09 April 2020

SEARS REQUEST FOR ADVICE – ESR HORSLEY LOGISTICS PARK (SSD-100436)

I refer to your recent correspondence requesting feedback from Fairfield City in relation to the Secretary's Environmental Assessment Requirements (SEARs) for SSDA 10436 at 6 Johnston Crescent, Horsley Park comprising the following:

LOT 201 STORMWATER DRAINAGE PLAN
SCALE 1500

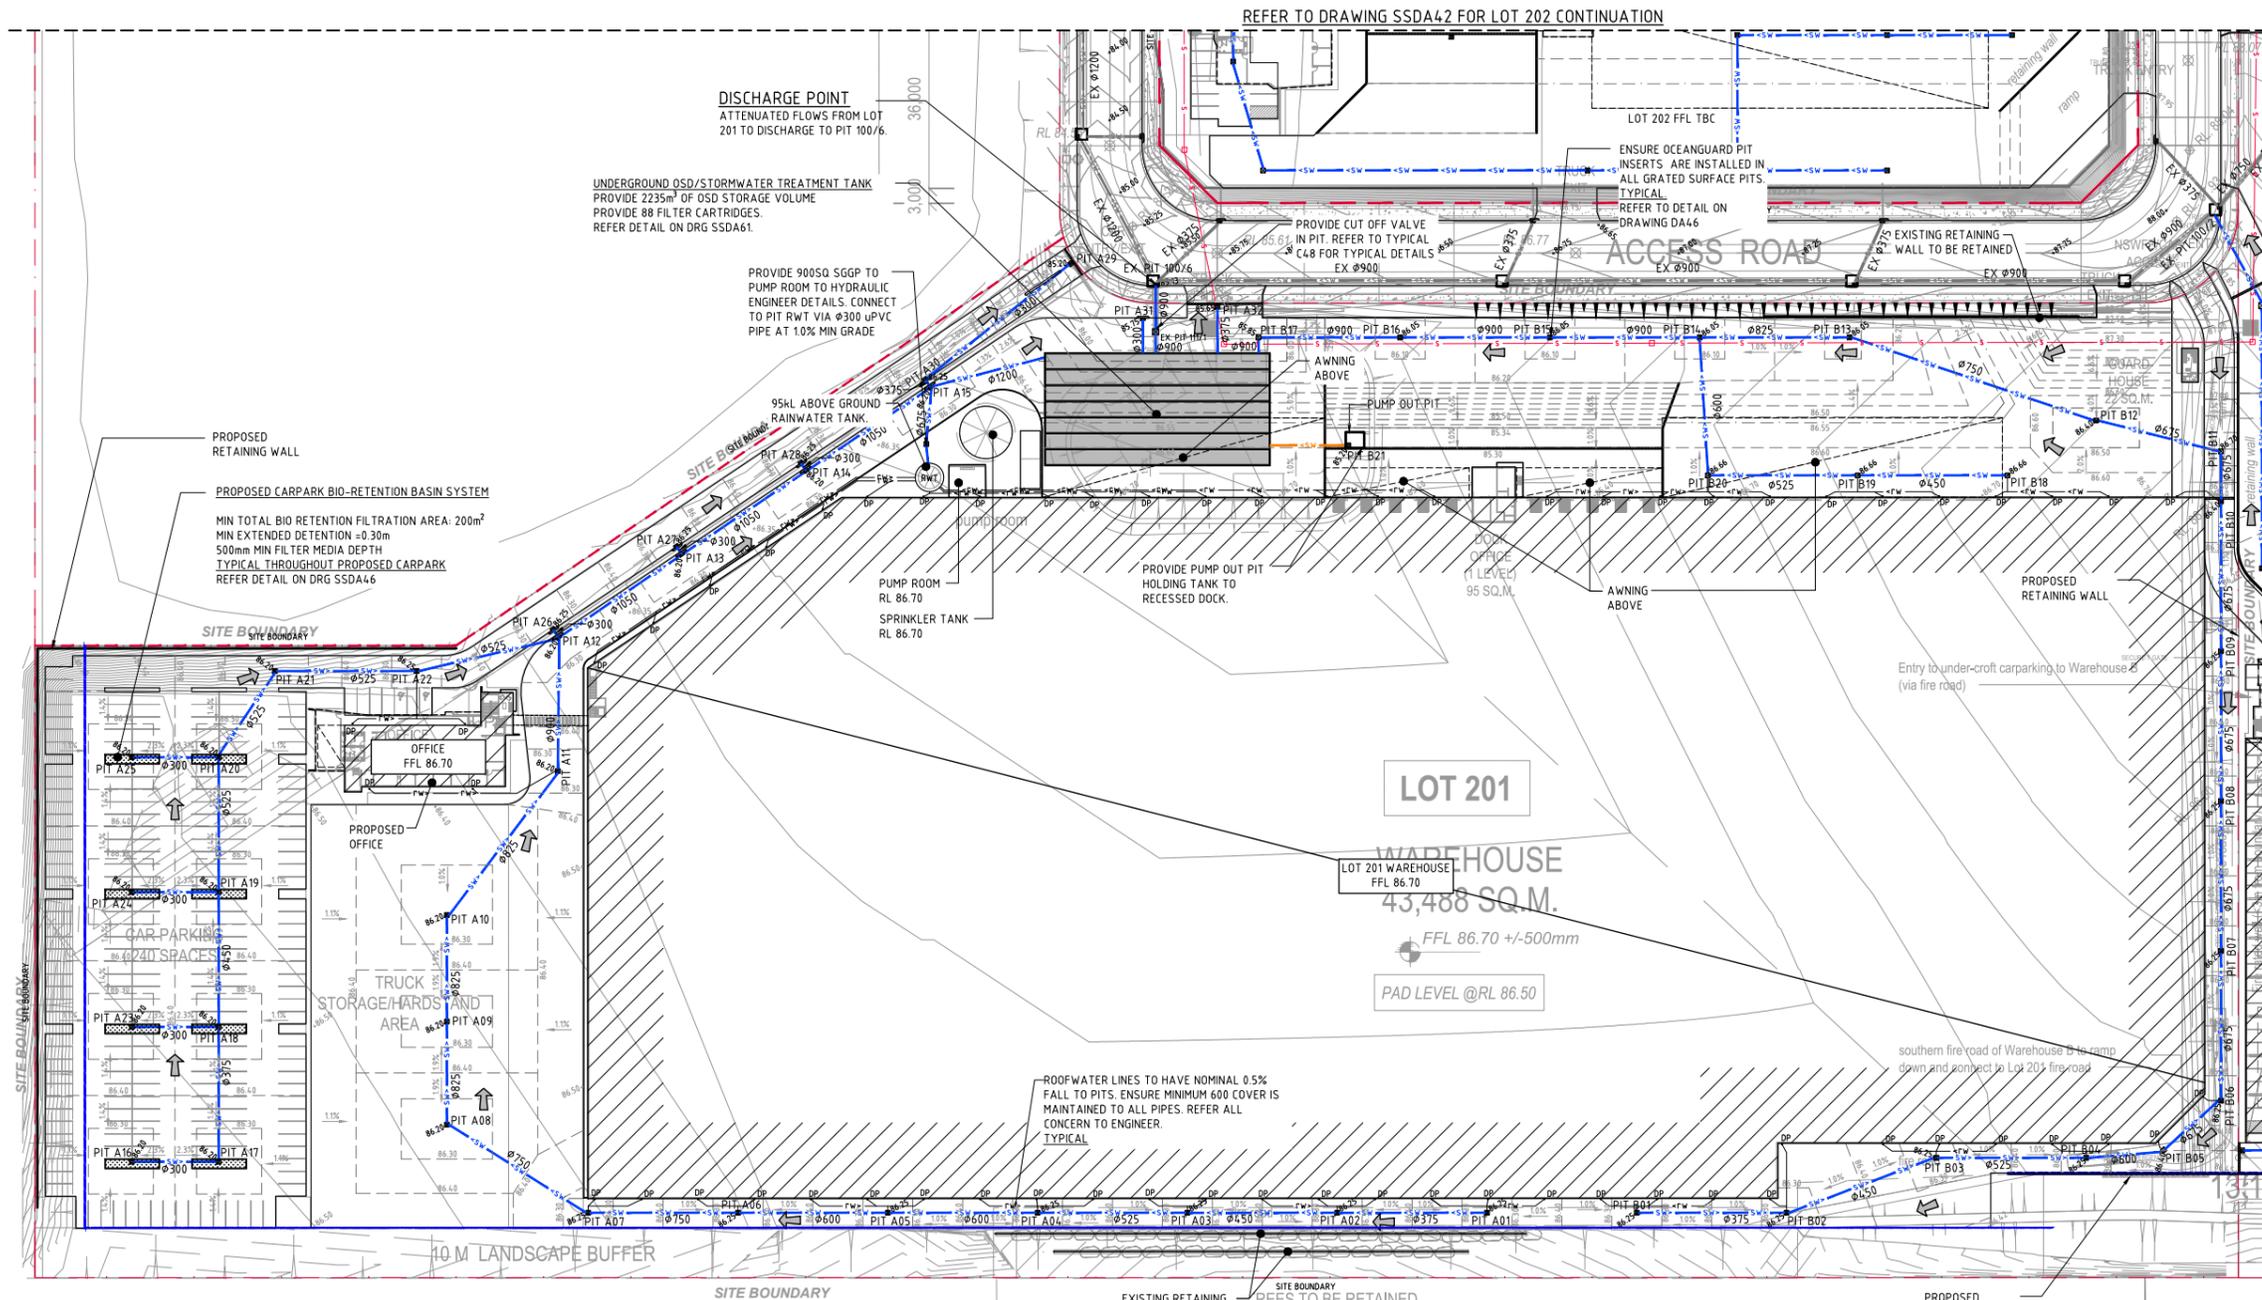
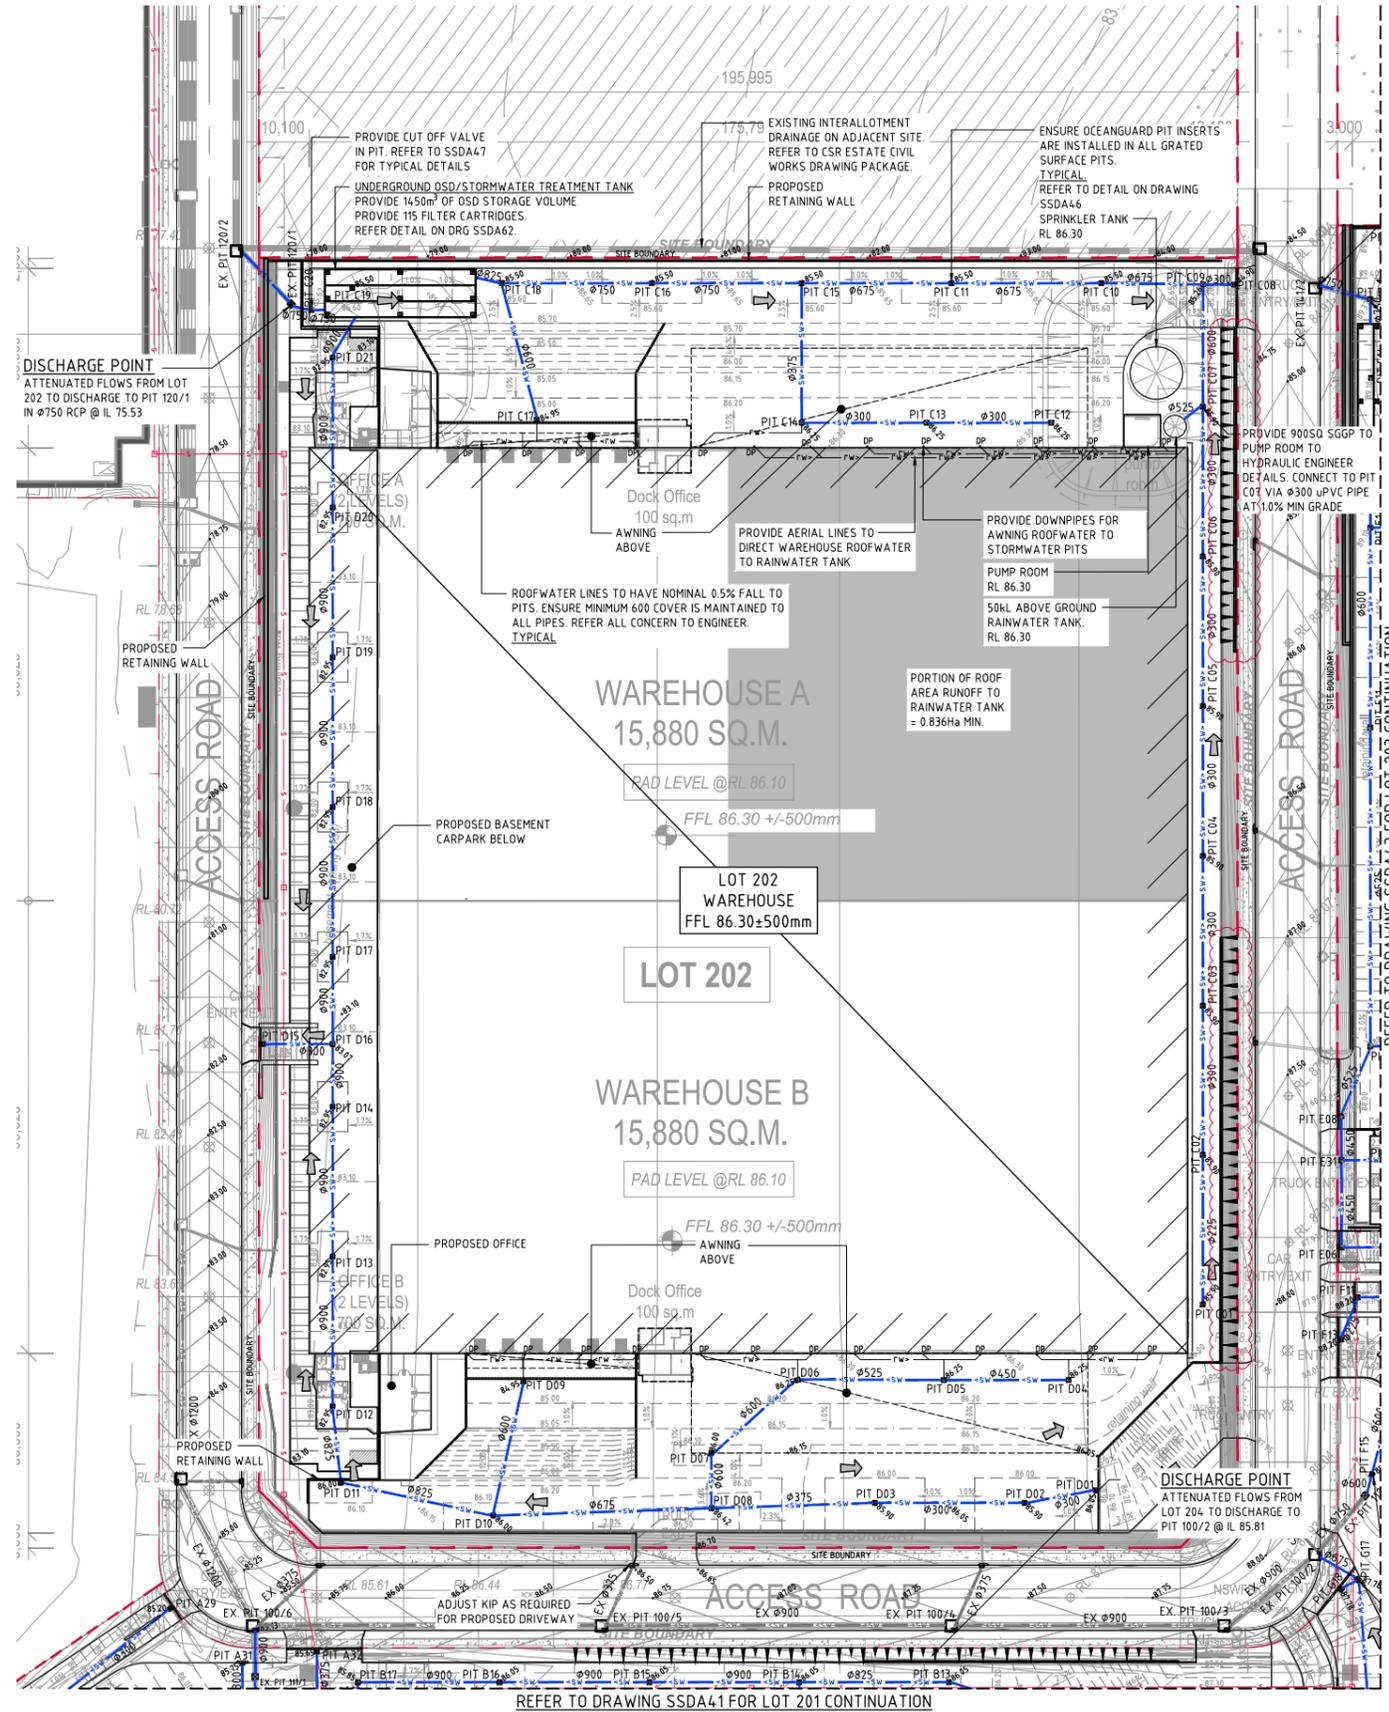
Stormwater drainage for the proposed development in Lot 201 shall be provided in accordance with Site Specific DCP 327-335 Burley Road Horsley Park dated March 2016. A stormwater drainage plan is to be prepared by a qualified engineer and shall be submitted with the EIS. In particular, the following shall be incorporated in the stormwater design.

1. On site Detention system (OSD) shall be designed for the proposed development to comply with PSD and SSR requirements as noted in Clause 6 Section 3.2 of the above mentioned Site Specific DCP.
2. Water quality measures shall be implemented to meet gross pollutant trap performance criteria as noted table 4 in Section 3.2. MUSIC model used in the design shall be submitted to Council.

LOT 201 FINISHED LEVELS PLAN - SHEET 1
SCALE 1:500

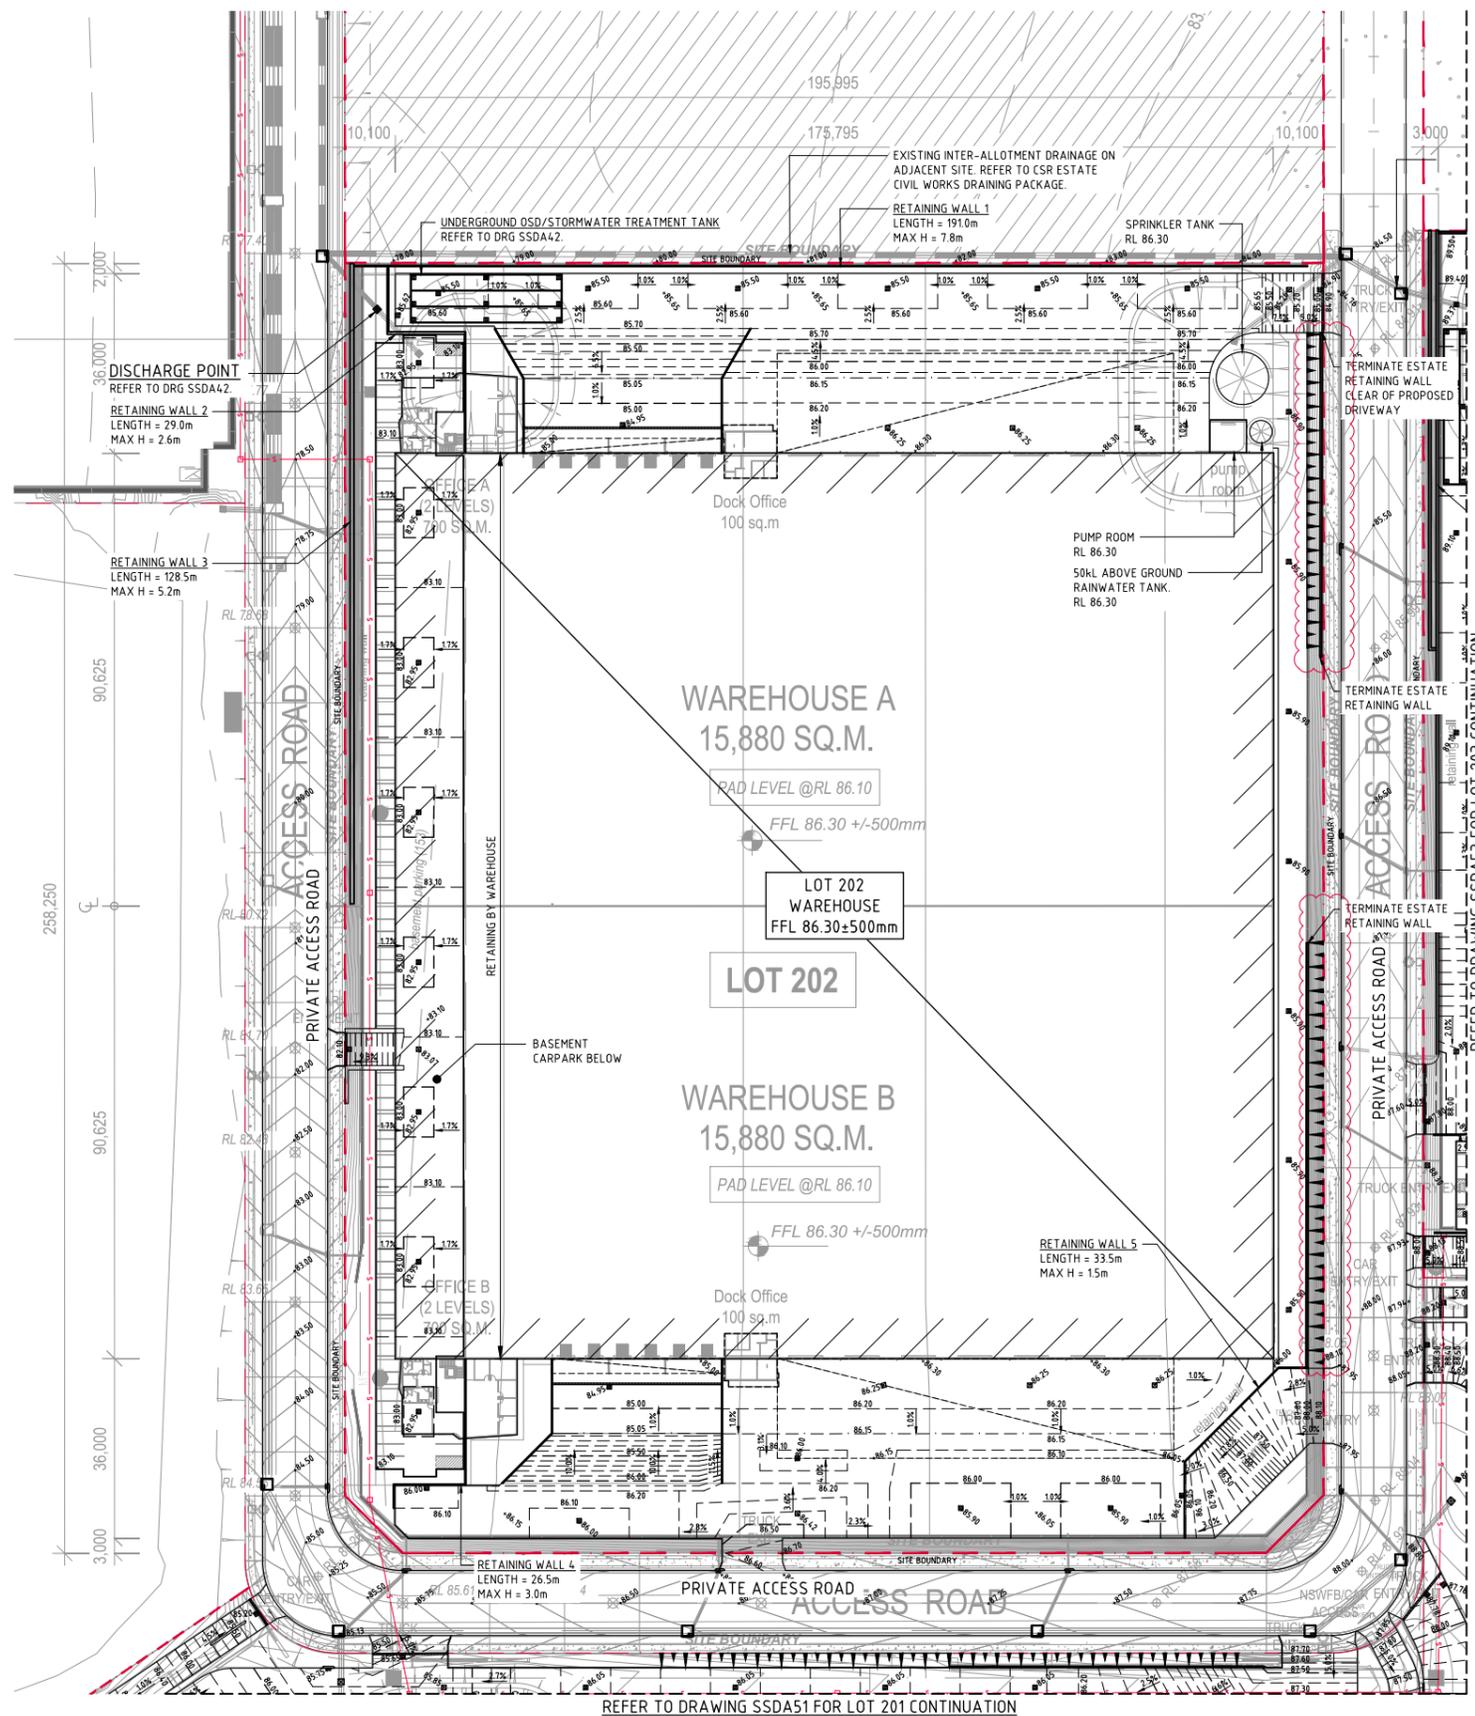
The ultimate building pad level will remain at RL 86.5m on Lot 201 and RL 89.1m on Lot 202 for any future building. A restriction on the Use of Land shall be imposed to ensure any future building on Lot 201 and 202 is restricted to the applicable building pad level."
